Consultation Response from Mark Berry KC, Highways Development Management
2023/91342 Moss Edge Farm, Moss Edge Road, Holmbridge, Holmfirth, HD9 2SD
Prior notification for change of use from agricultural building to three dwellings with associated works
Date Responded: 16-8-2023. Responding Officer: Mark Berry Responding Ref: 3-25-1.

The applicants have provided revised plan numbers 166-23-PL101 rev E showing gradients, widths, passing places and photographs showing the condition of the access track and PL 102 rev A showing refuse vehicle turning and additional off-street parking.

Client		
D. HELEINE		
Project		
MOSS EDGE FARM HOLLIN BRIGG HOLMBRIDGE HD9 2SD		
Drawing Title		
PROPOSED SITE LAYOUT		
Scale (at A1)		Date
AS SHOWN		28.02.2023
Drng. no.	166-23-PL102	Rev.
		A

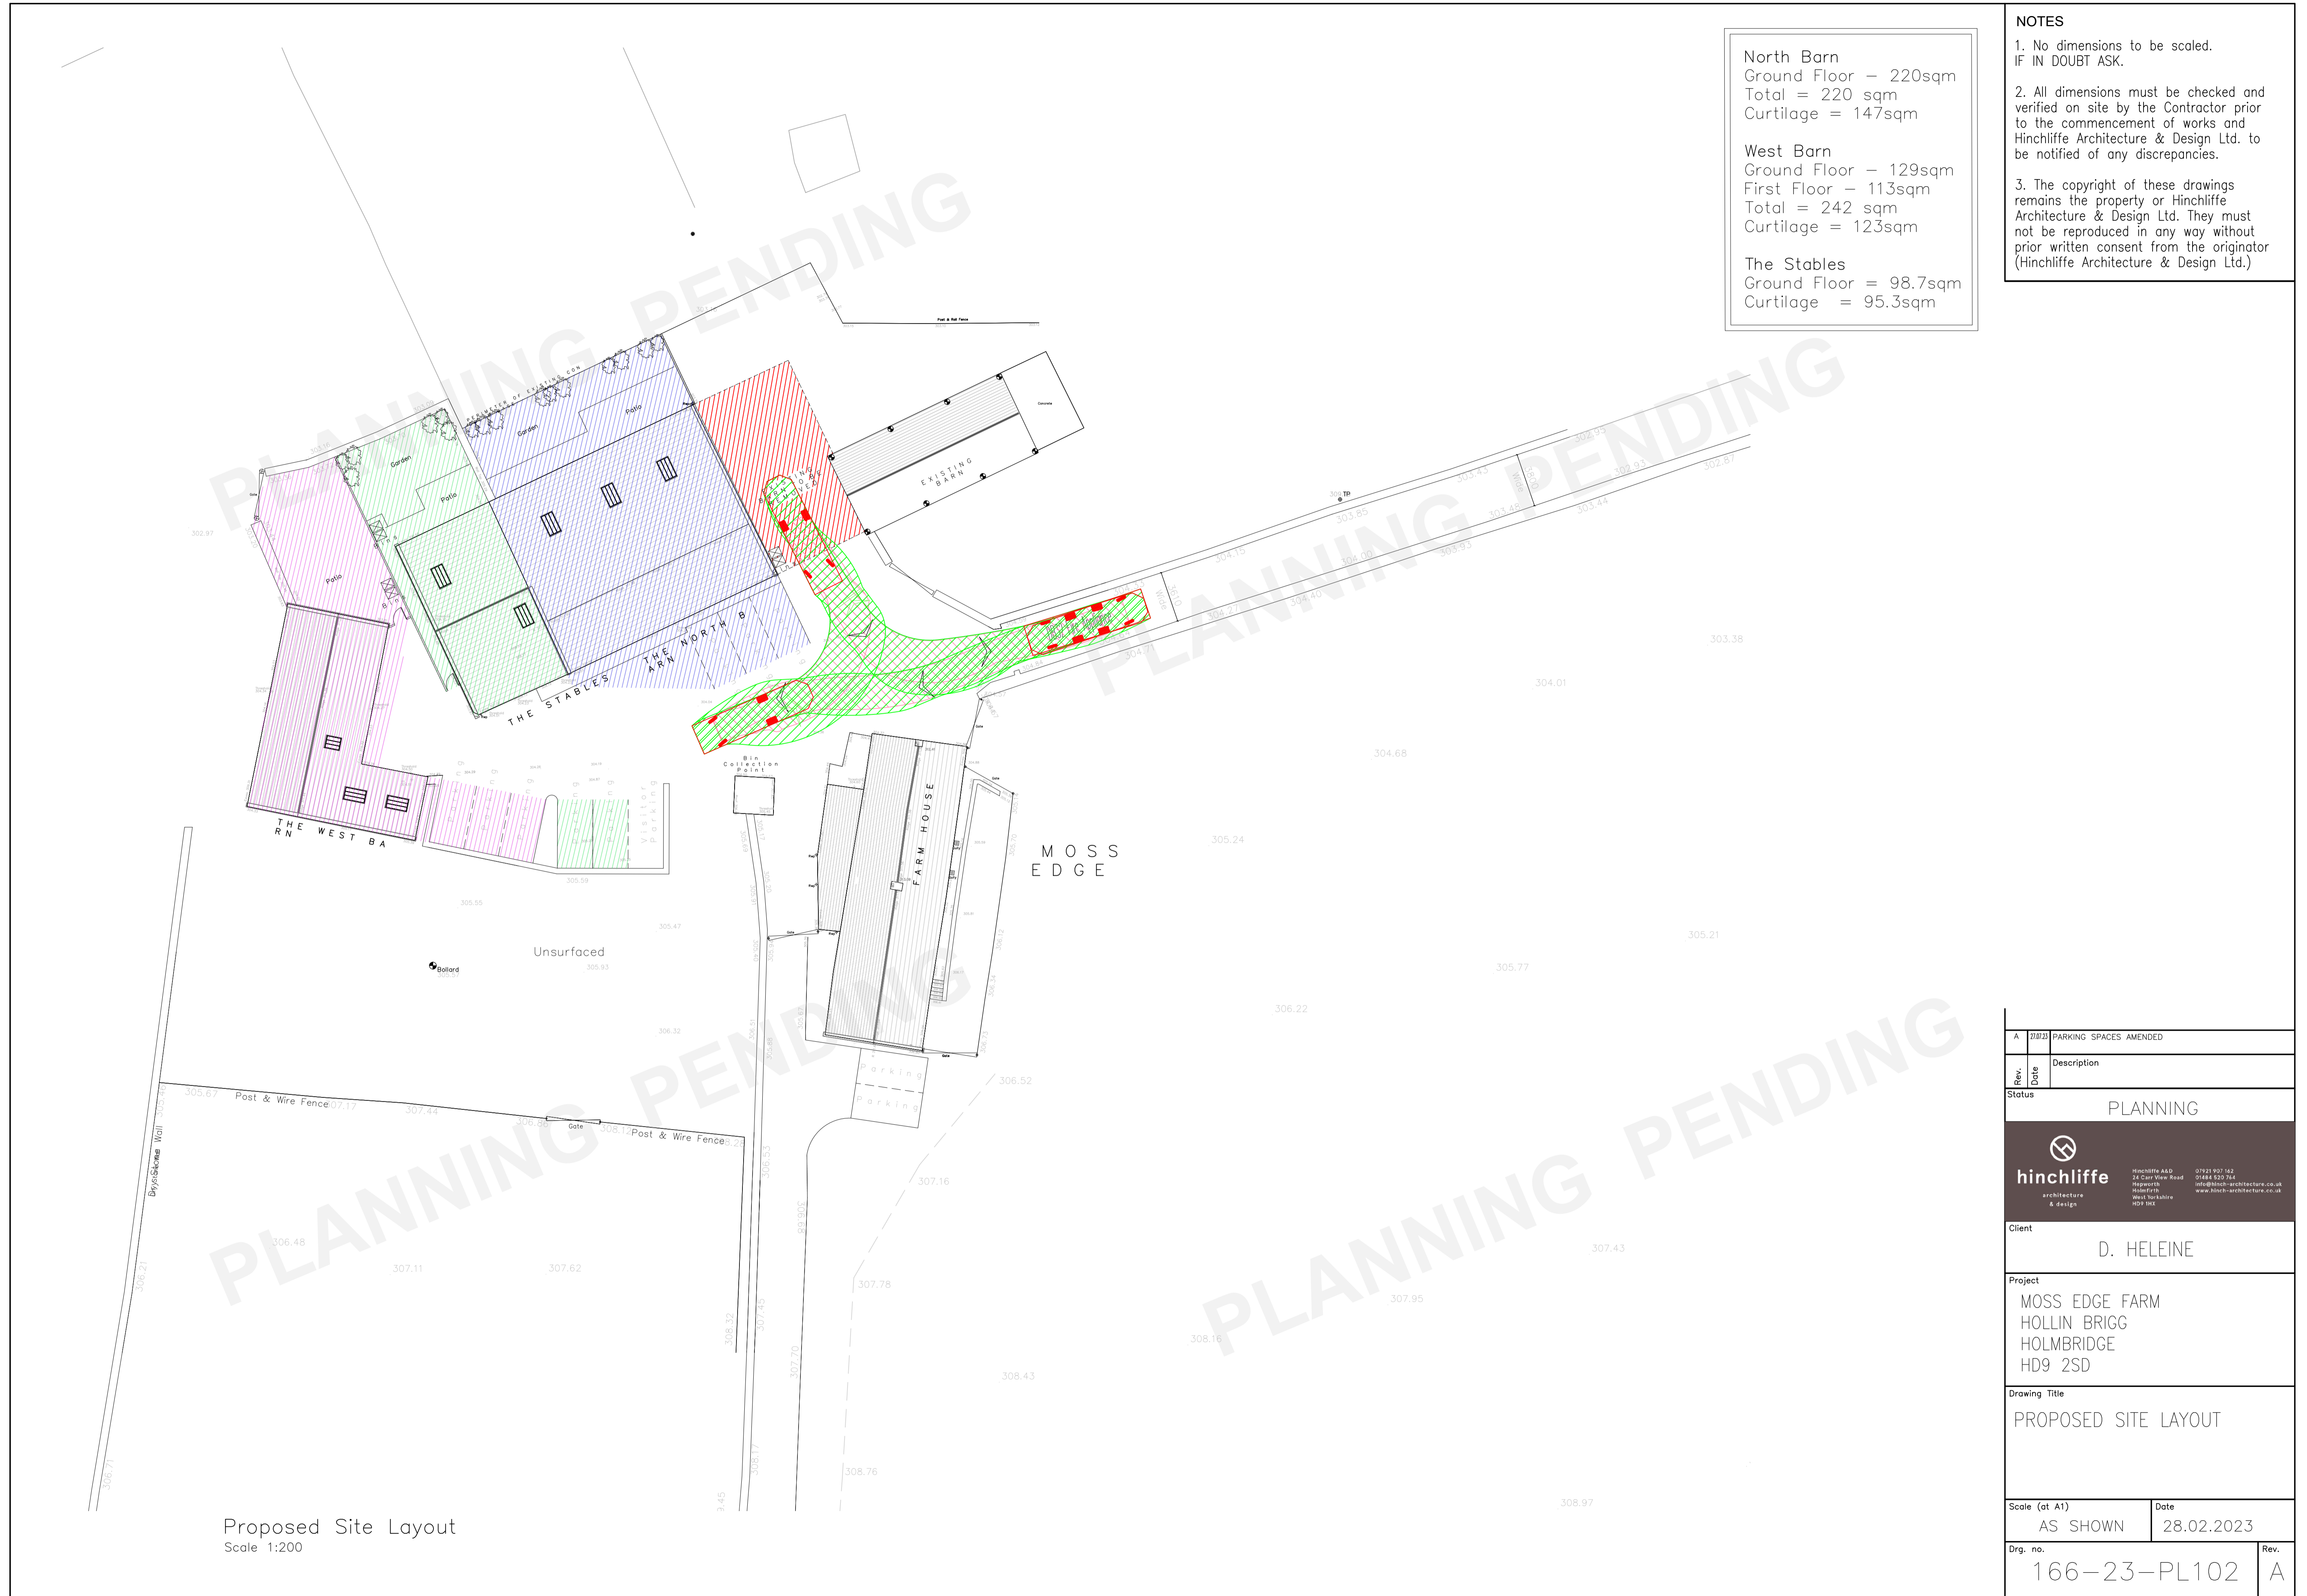
Refuse vehicle turning is shown within the site and sufficient off-street parking is shown for the proposed dwellings.
